# CITY OF ALBUQUERQUE

**Re: Sandia View Assisted Living**  
**8211 Cutler Ave, 87110**  
**30-Day Temporary Certificate of Occupancy**  
**Transportation Development Final Inspection**  
Engineer's/Architect's Stamp dated 2-4-20 (H19D089)  
Certification dated 1-8-21

SHEET NAME:
TRAFFIC CIRCULATION LAYOUT

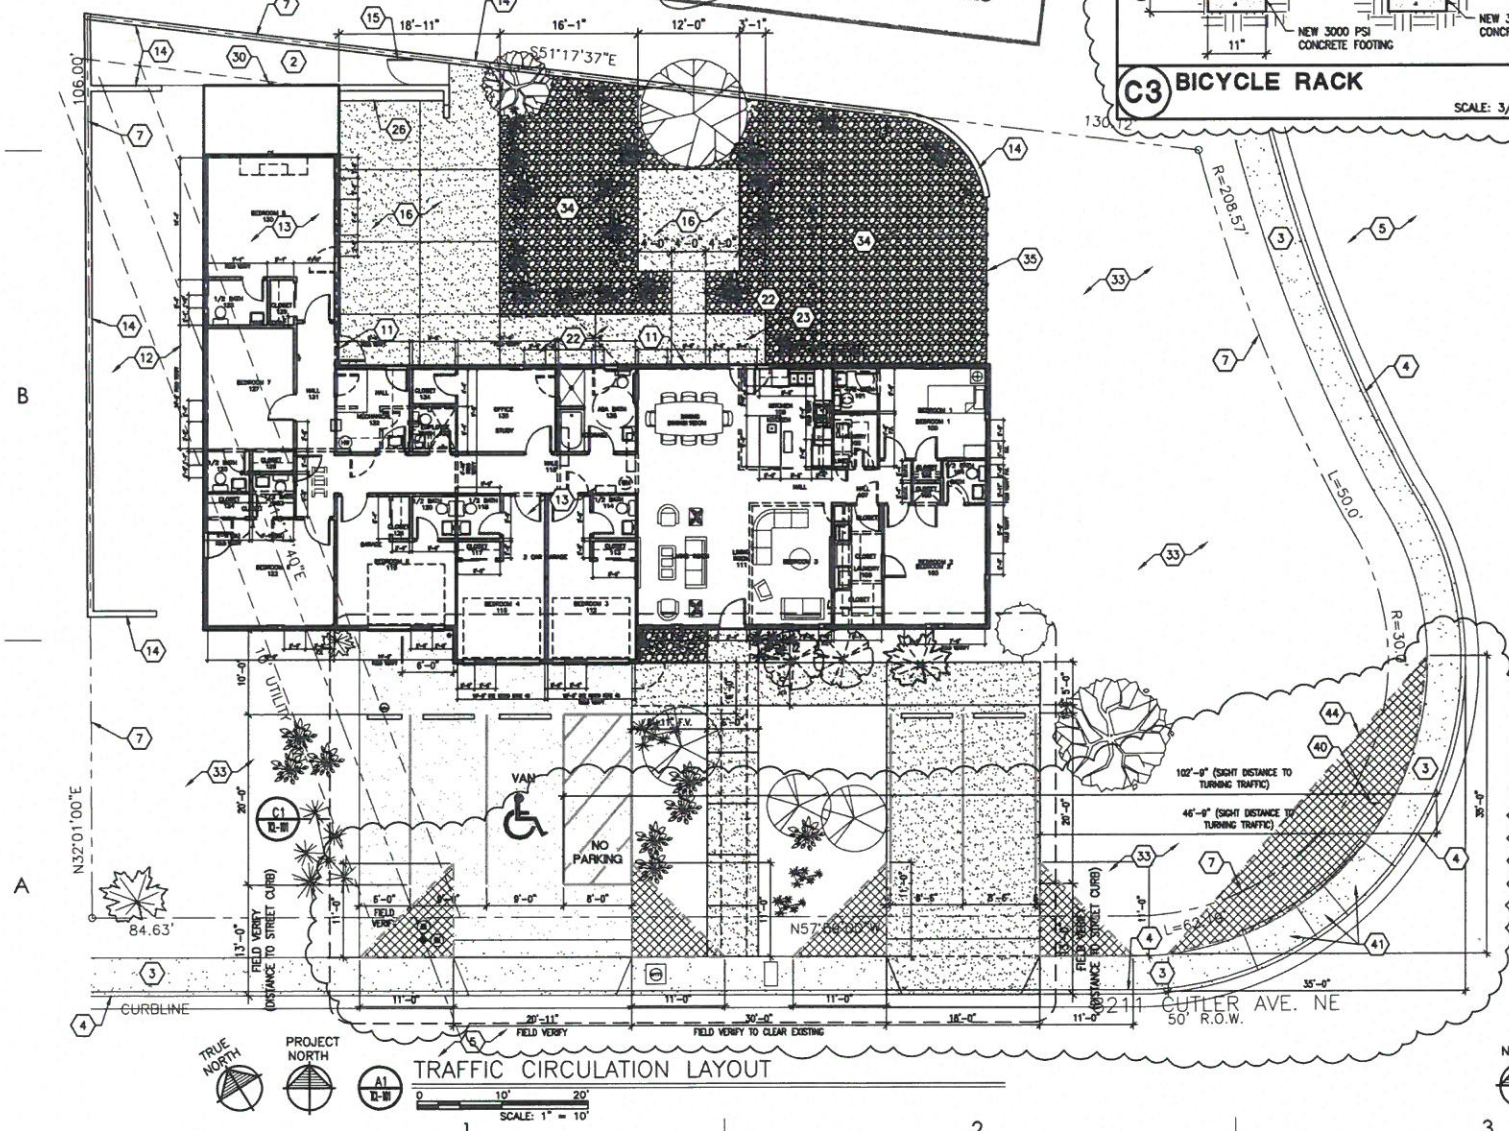
- Please remove or trim landscape bush to be no higher than 3 feet. Clear site issue with one of the drives. See attached photo.
